From: Anita Gardner
Sent: 24 January 2019 14:13
To: Planning.Responses
Subject: FW: Gladwyn
Attachments: 2386_01_02.pdf; 2386_01_03.pdf

Please see the revised drawings following comments from EPPC and WSCC. The dormers have been altered slightly, extra parking is demonstrated and the visibility splays drawn in.

Project: Proposed new homes; Gladwyn, The Street, East Preston BN16 1HT			
Drawing: Block plan, bin store elevations			
For: Mrs. J. Simmonds & Mr. P. Beamish			
Drawn: PKS		Date: November 2018	
Scales: 1:50 1:200		No: 2386/01/03/C	
To scale when printed on A3

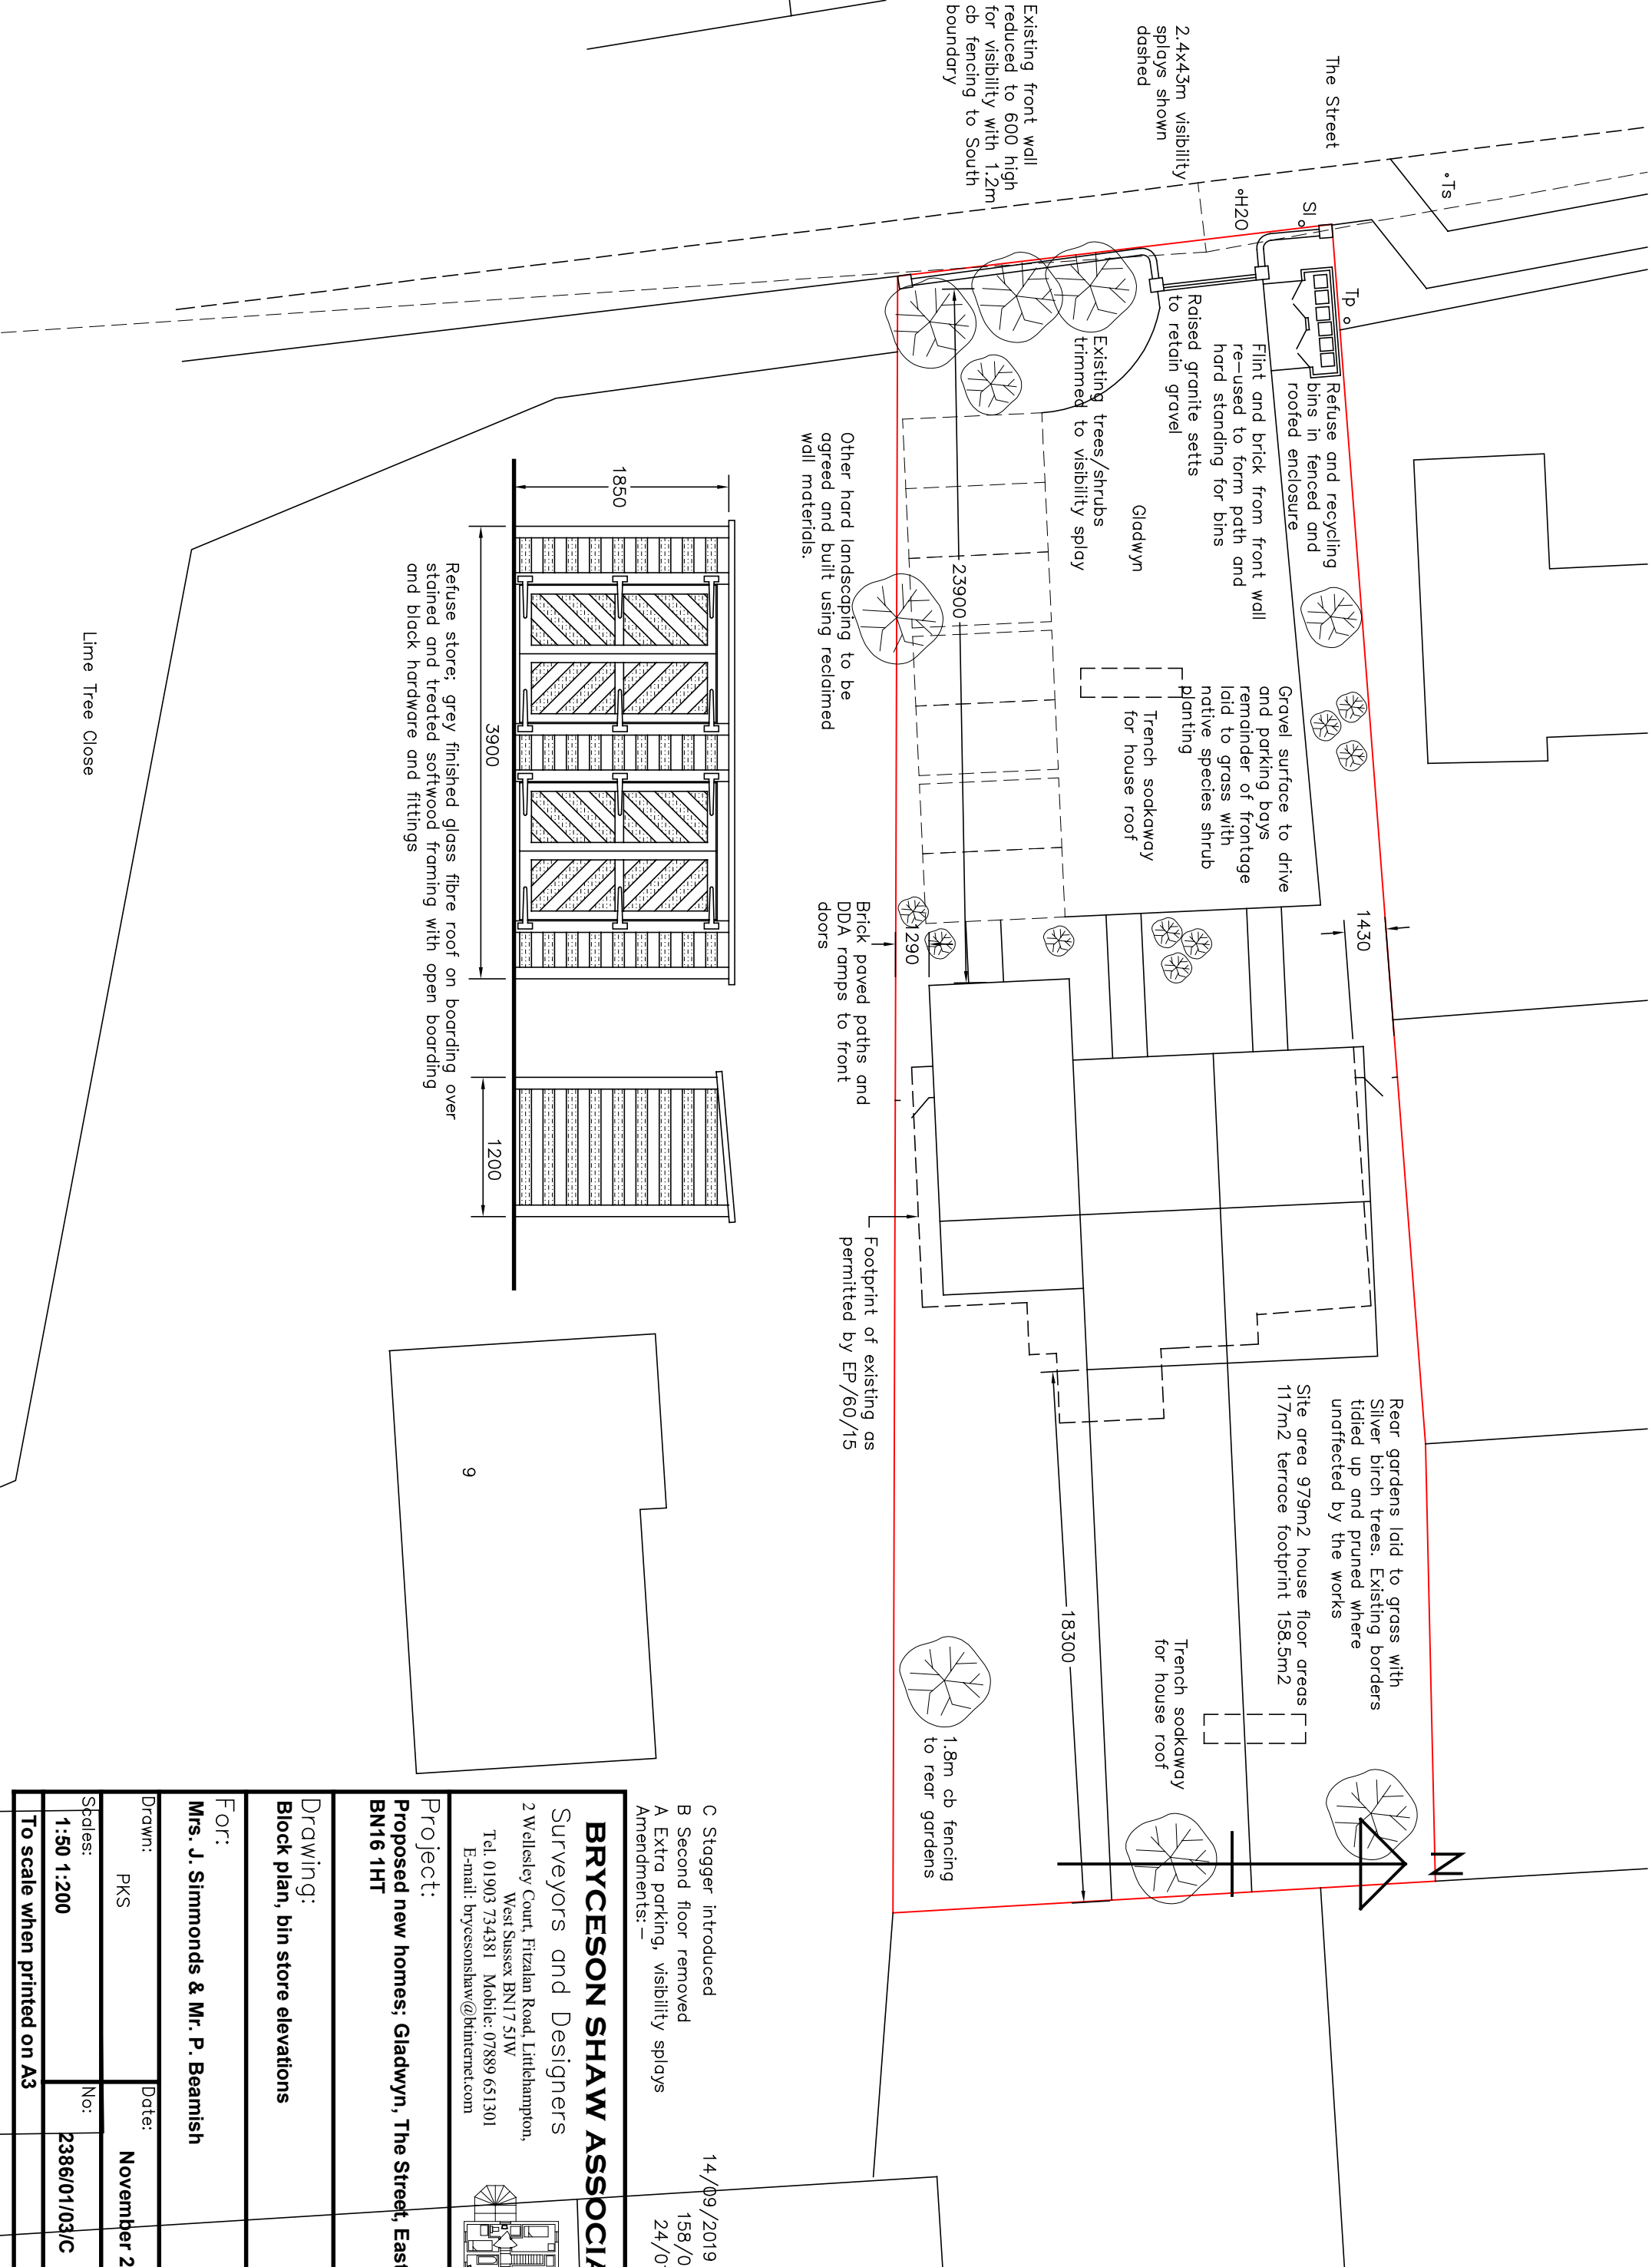
The splays just result in the reduction of the majority of the front garden wall to 600mm high and probably the removal or severe trimming of the shrubs against it.
